Department of Primary Industries

OUT15/1414

Thank you for your email of 21 January 2015 concerning the review of the Environmental Impact Statement (EIS) and Agricultural Impact Statement (AIS) for the proposed Mt Owen Continued Operations Project.

Exhibition of *Mt Owen Continued Operations Project - SSD 5850* - Response to EIS & AIS.

**Figure 2C:** Project Layout – Hebden Road Upgrades

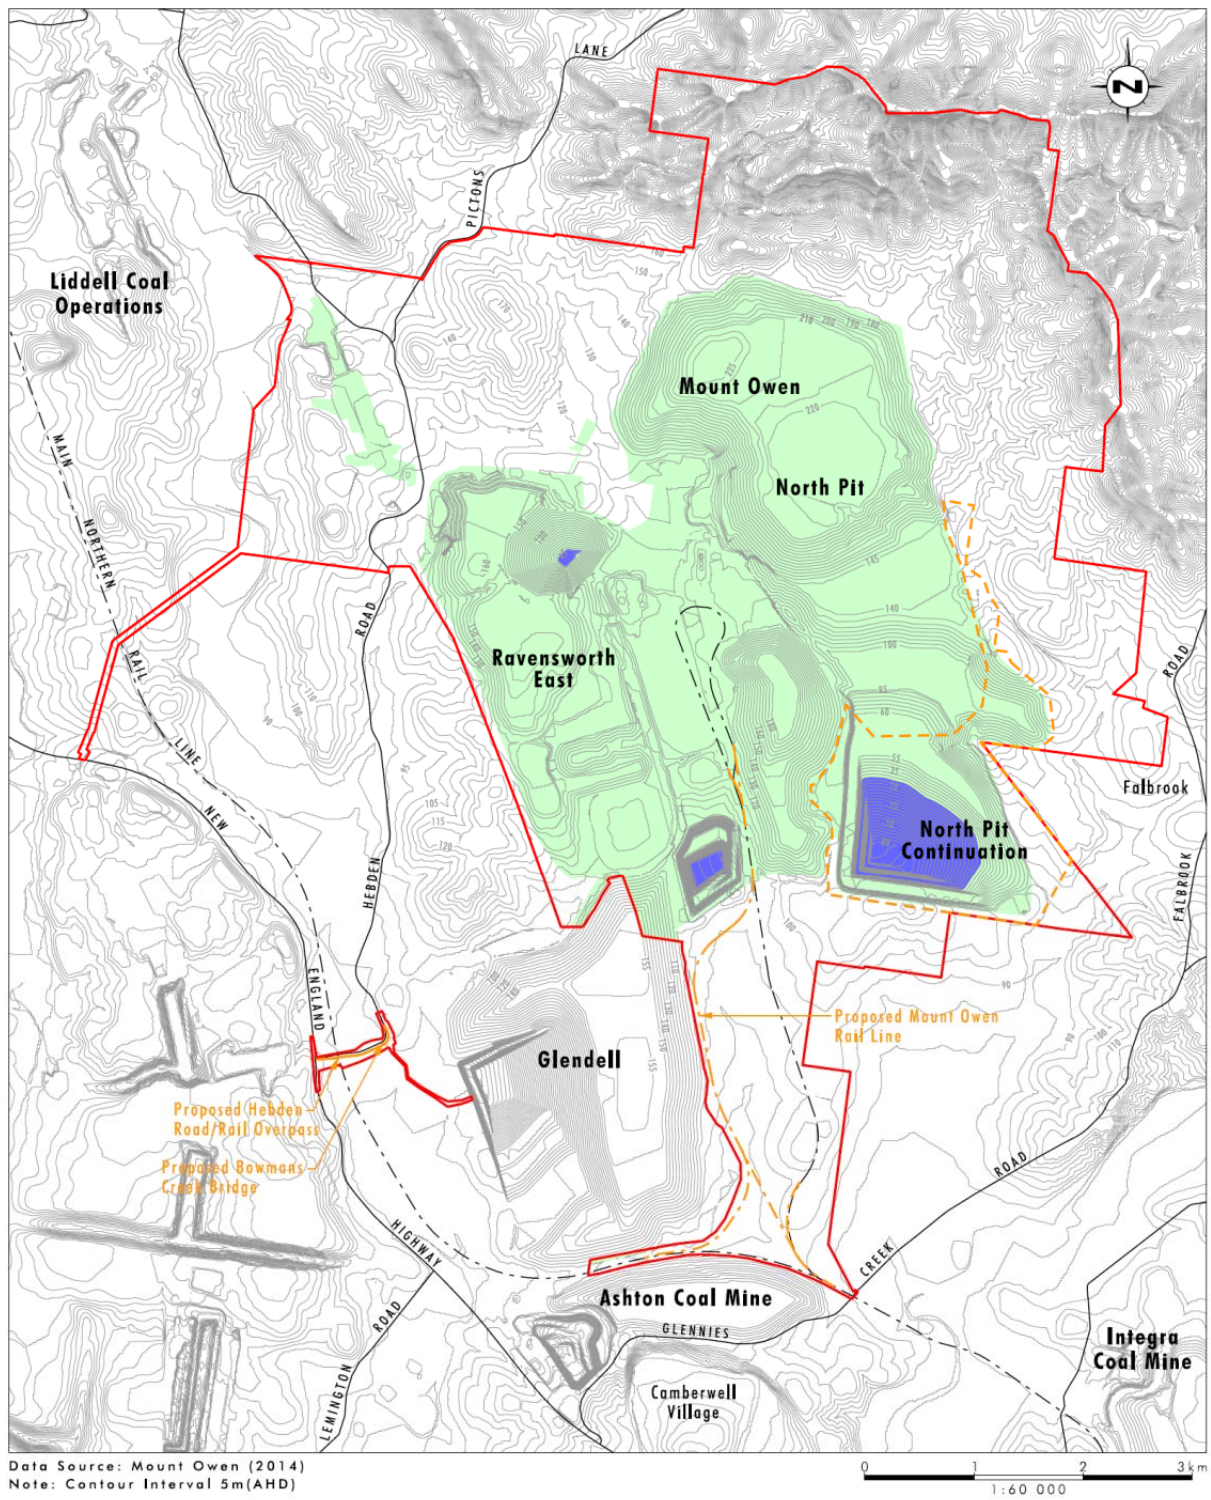
There is an existing single lane bridge on Hebden Road across Bowman's Creek which is proposed to be upgraded to a dual lane bridge. Hebden's Road intersects BSAL at Bowman's Creek so there will be some disturbance of BSAL as a result of the upgrade. This bridge upgrade is not expected to impact on the agricultural productivity of the BSAL since this disturbance is on an existing road and this small area of BSAL is currently not used for agriculture and is not likely to be used for agriculture in the future.. There are no agricultural production issues raised in relation to this issue.
